From: Simon Davis
Sent: 09 September 2021 12:52
To: 'Susan Leeson' [REDACTED]
Cc: Andy Peppler [REDACTED]
Subject: RE: Brook View Nursery WA/58/21/PL

Proposed Block Plan
Scale 1:500

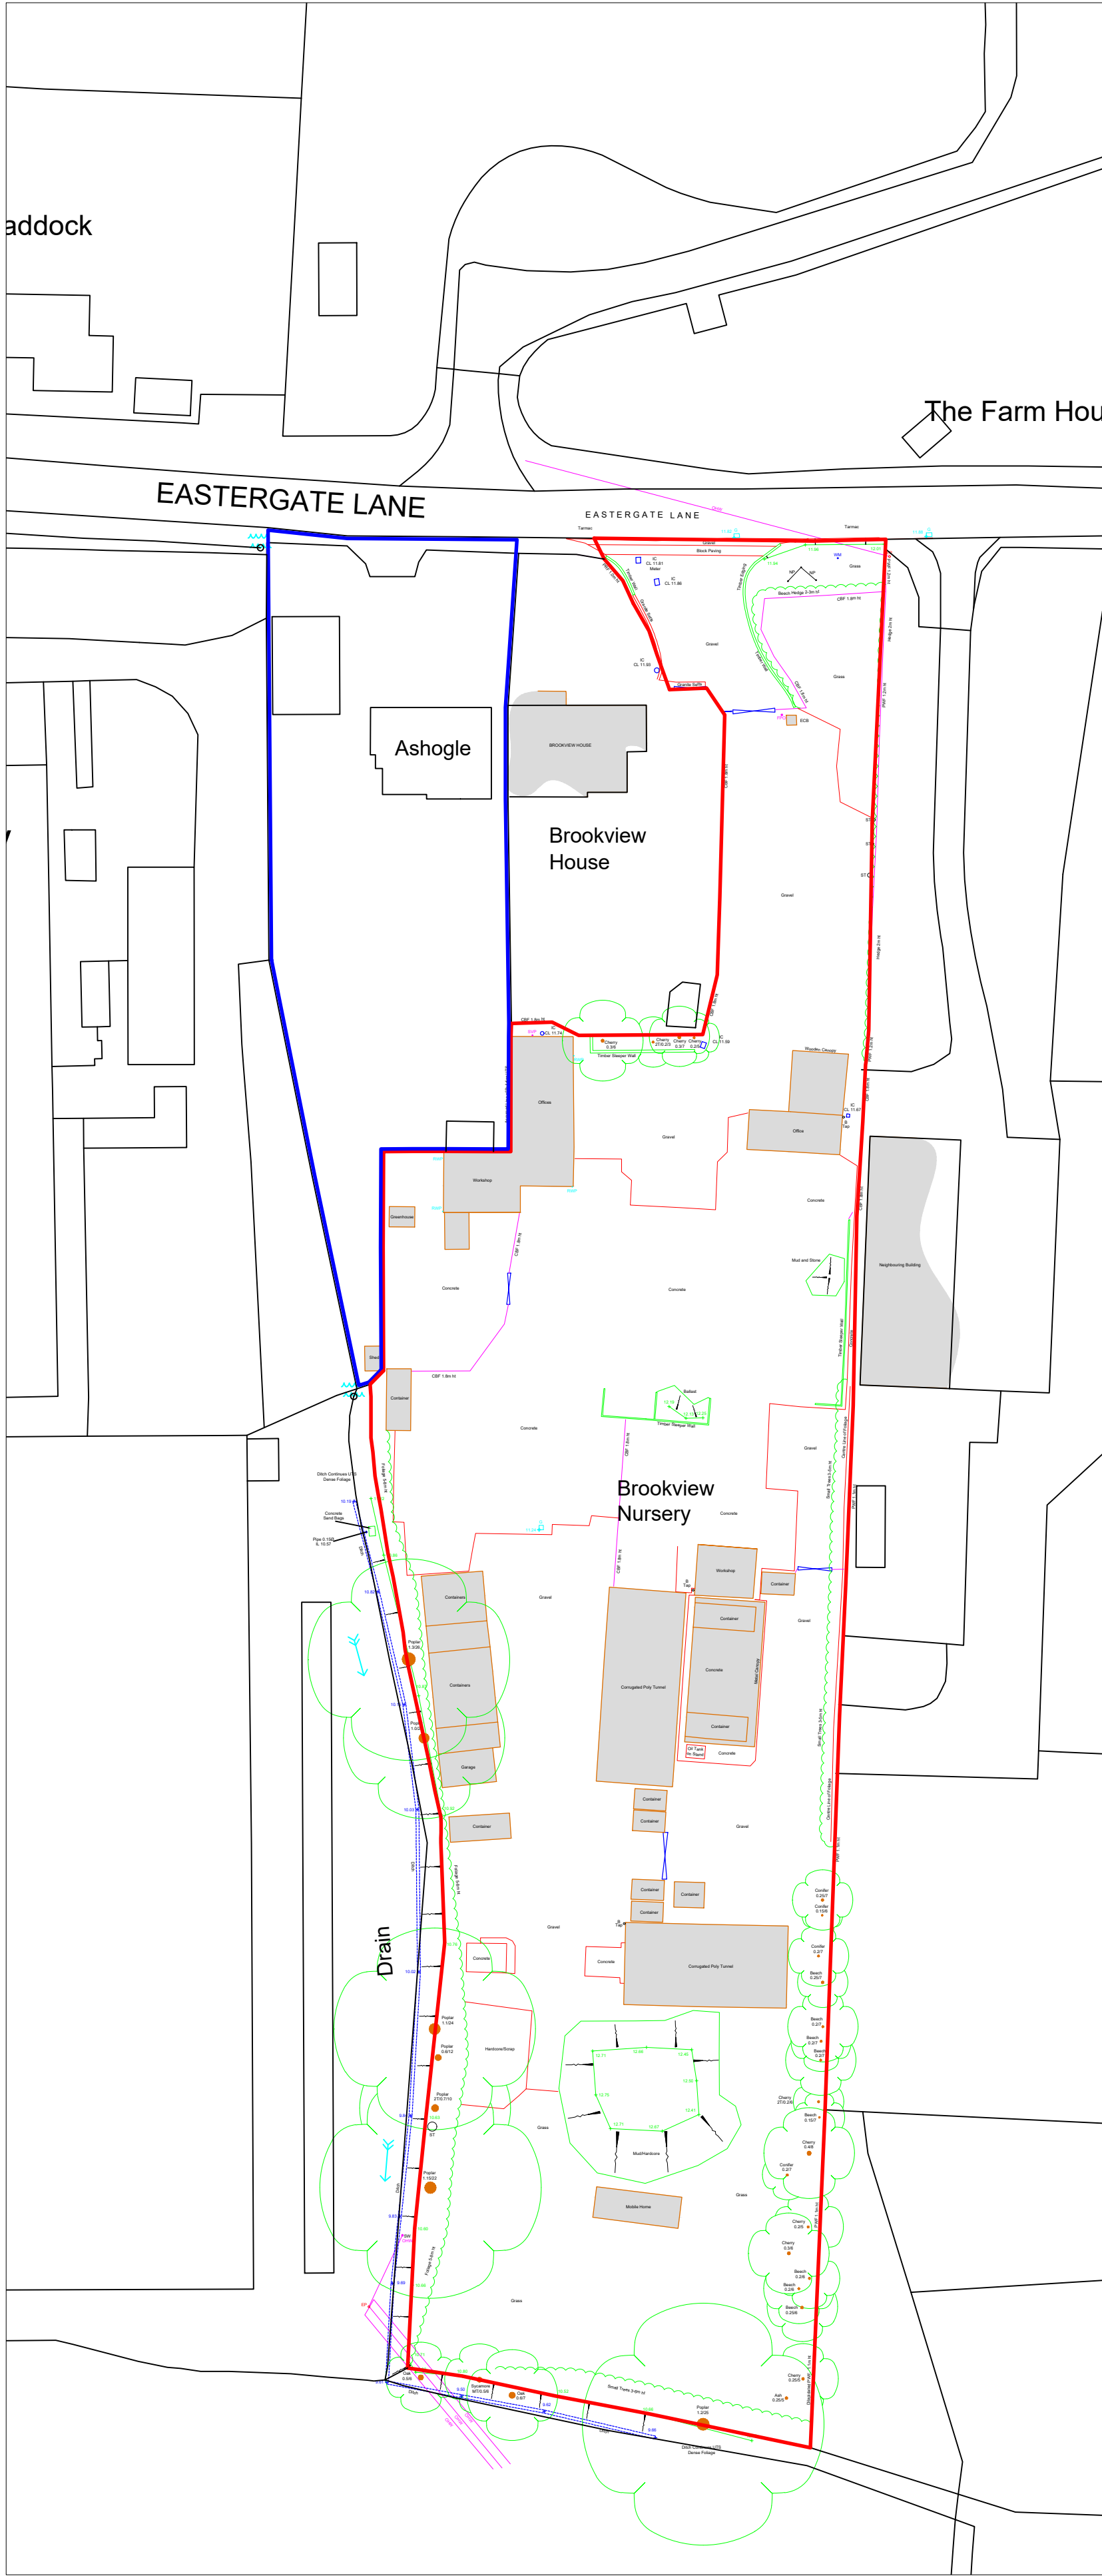
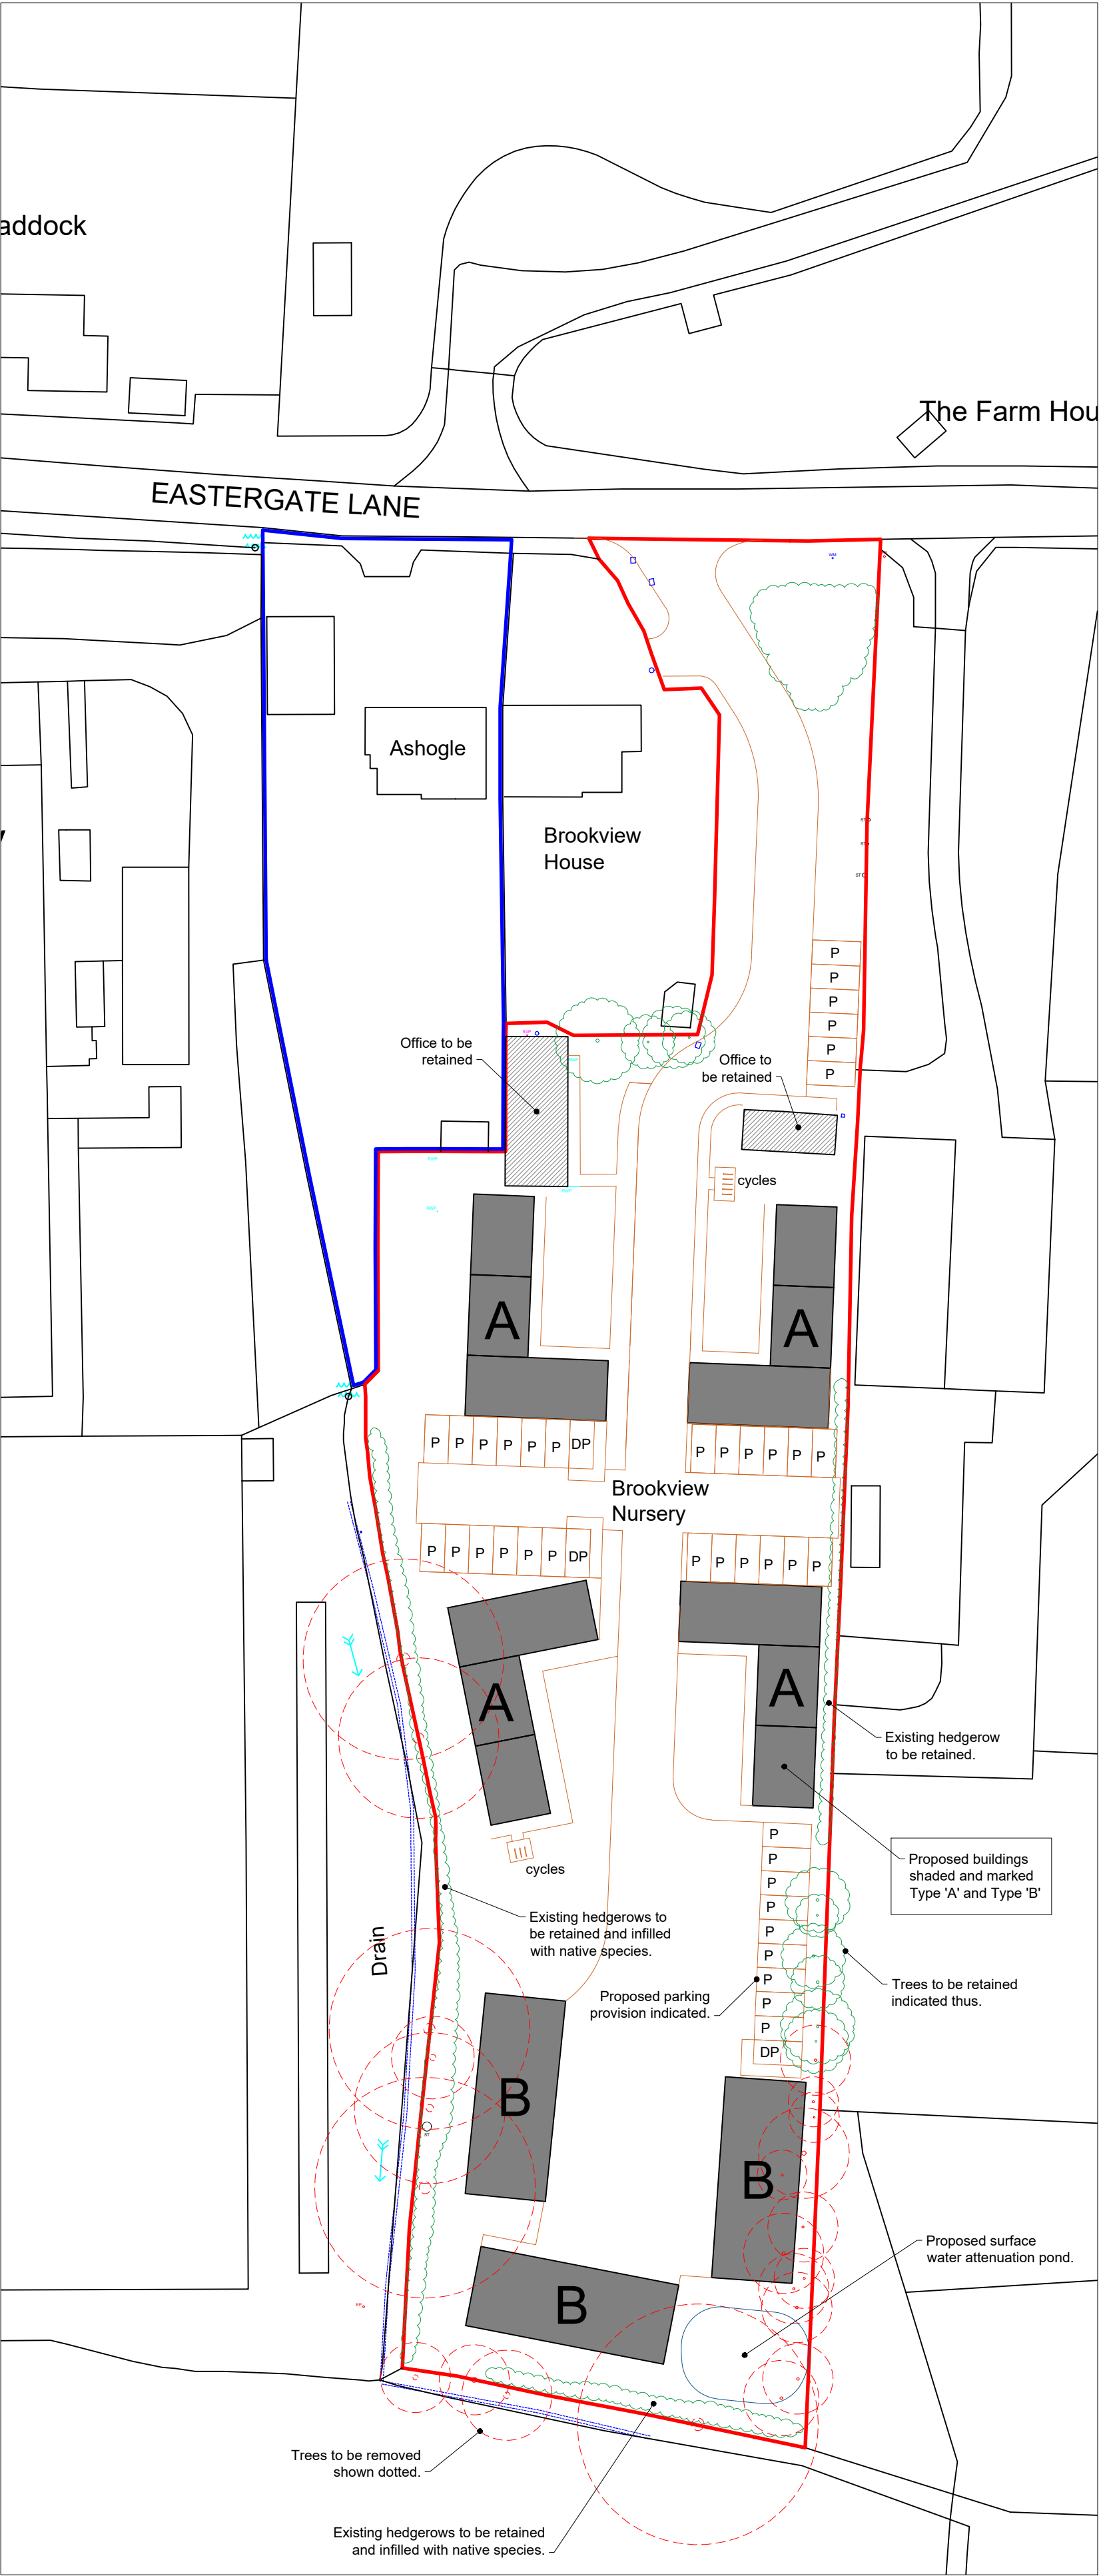
I would suggest that you digest the officer report and resubmit with the outstanding items/changes to the layout to retain more trees at the southern end of the site. I also note that the submitted Tree Protection Plan 1 and 2 appear to be the same (both for the northern part of the site).
